Our ref: NO/2020/112450/01-L01
Your ref: 3/2020/0017

Date: 25 February 2020

**CONSTRUCTION OF A PLAY BARN/ACTIVITY CENTRE.
HAWKSHAW FARM, LONGSIGHT ROAD, CLAYTON-LE-DALE BB7 2JA**

# Hawkshaw Farm Location Plan.

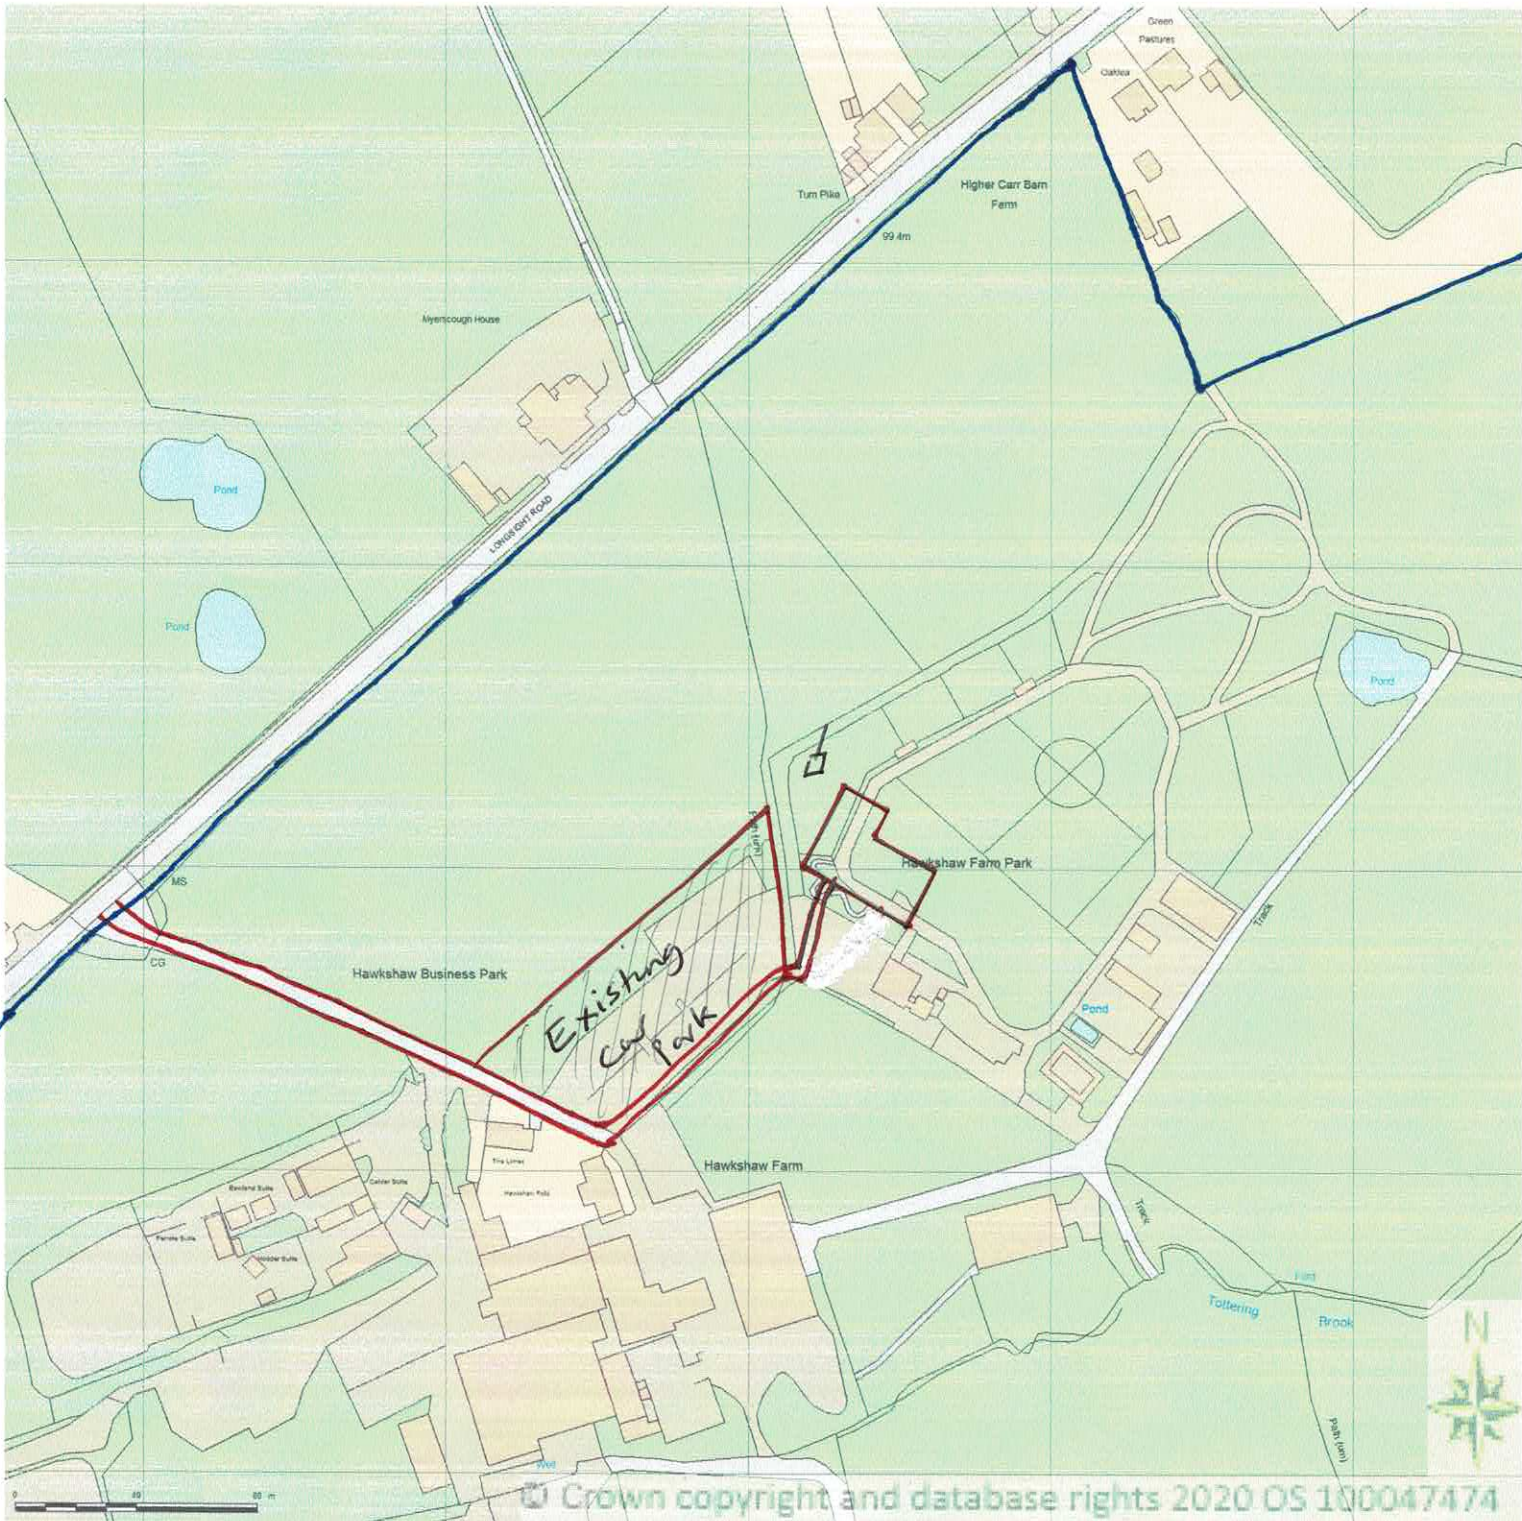
We have no objection to the development as proposed, however we would take this opportunity to remind the applicant of the rules governing the disposal of foul water to non-mains drainage, as is proposed in this case. An amendment/alteration to the existing environmental permit may be required.

Foul drainage should be connected to the main sewer. Where this is not possible, under the Environmental Permitting Regulations 2010 any discharge of sewage or trade effluent made to either surface water or groundwater will need to be registered as an exempt discharge activity or hold a permit issued by the Environment Agency, addition to planning permission. This applies to any discharge to inland freshwaters, coastal waters or relevant territorial waters.

A soakaway used to serve a non-mains drainage system must be sited no less than 10 metres from the nearest watercourse, not less than 10 metres from any other foul soakaway and not less than 50 metres from the nearest potable water supply.

Where the proposed development involves the connection of foul drainage to an existing non-mains drainage system, the applicant should ensure that it is in a good state of repair, regularly de-sludged and of sufficient capacity to deal with any potential increase in flow and loading which may occur as a result of the development.
